Planning reference:-
R/1529/12.

29th August 2013.

With reference to the proposed building application for Mr & Mrs K. Drew of 8 Westmead East Preston.

Proposed Elevations

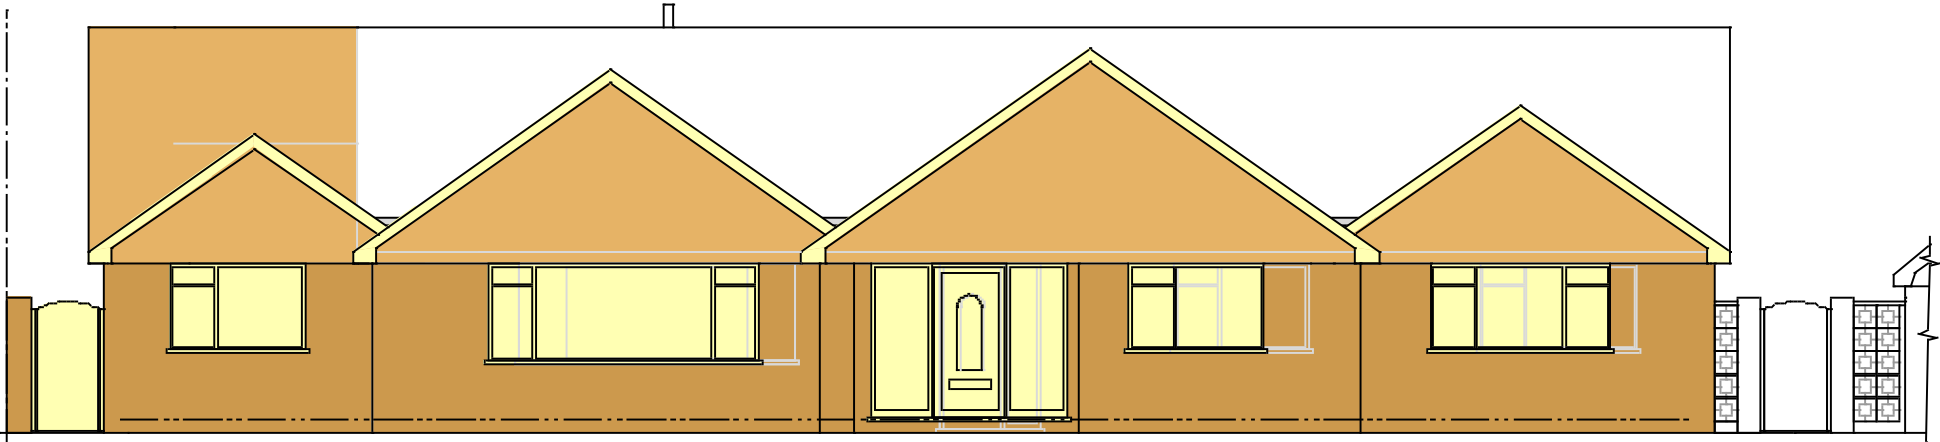
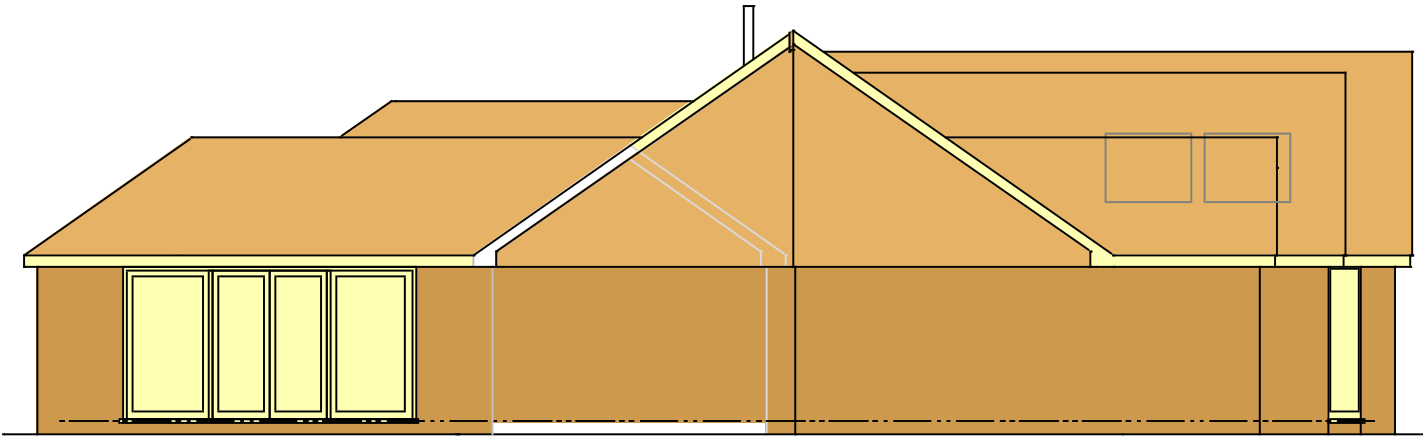
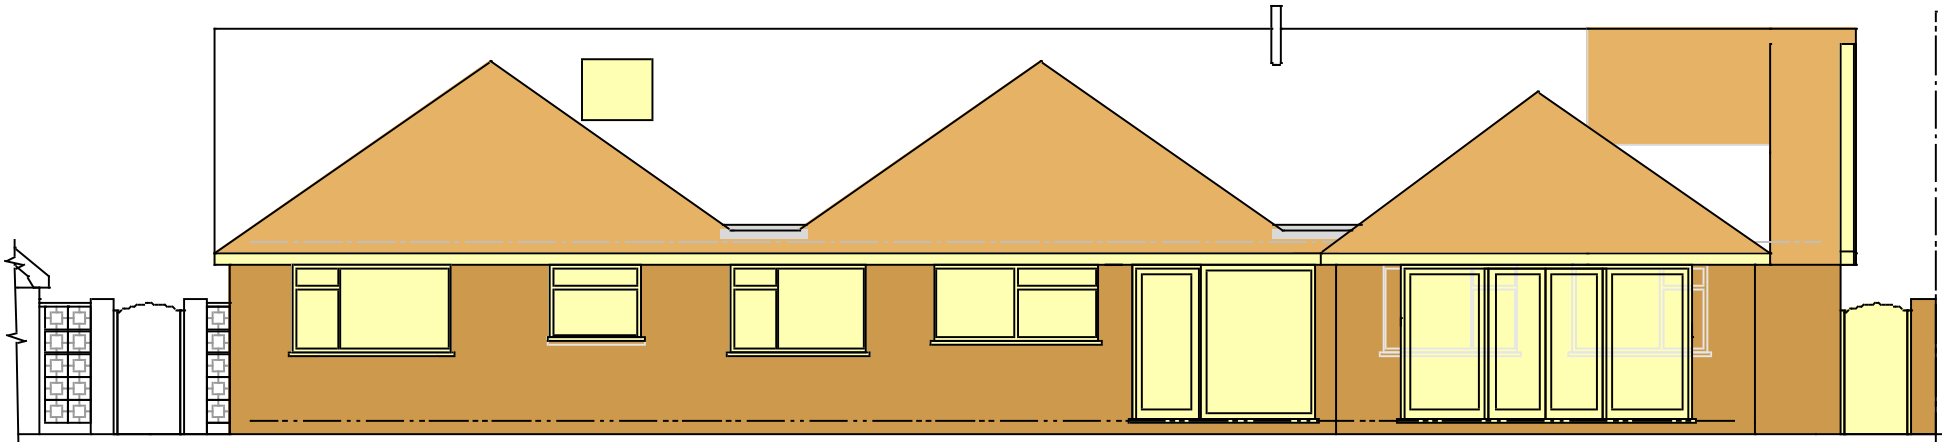
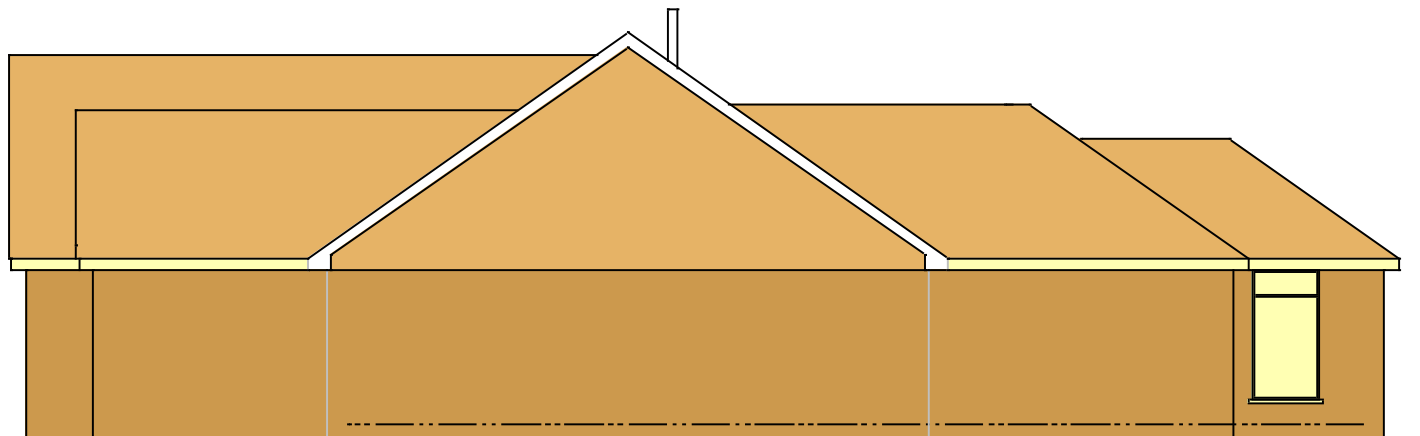
The pitched roofs at the West side of their property, thus being the East side of my property will be very invasive to:-

- ① Too near to my boundary fence line.
- ② my top floor bedroom, and bathroom windows
- ③ also my lower bedroom and bathroom windows.
